An  
Bord  
Pleanála

**Board Direction**  
**BD-014090-23**  
**ABP-316168-23**

The Board decided to grant permission generally in accordance with the Inspector's recommendation, for the following reasons and considerations, and subject to the following conditions.

Figure 14: Flood Extent Map with proposed infrastructure

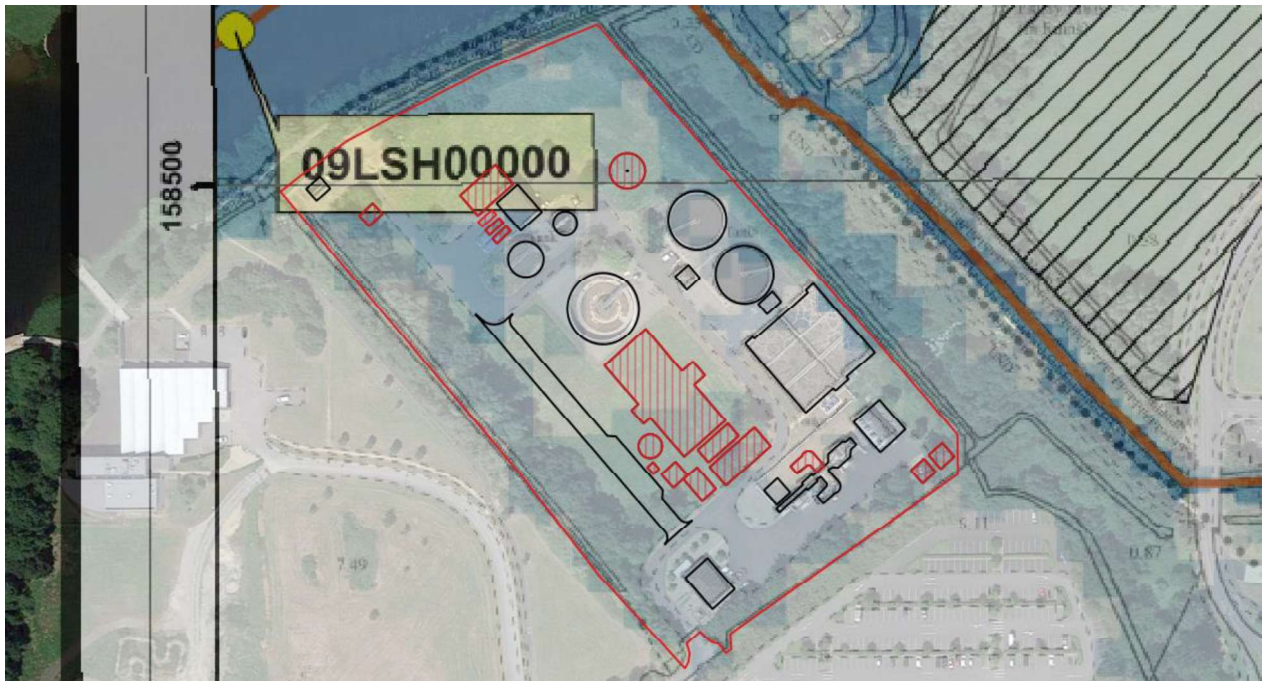
5. No part of the proposed compensatory flood storage shall be within Flood Zone A. A revised plan with the area shown thereon shall be submitted to the planning authority for written agreement prior to commencement of development.
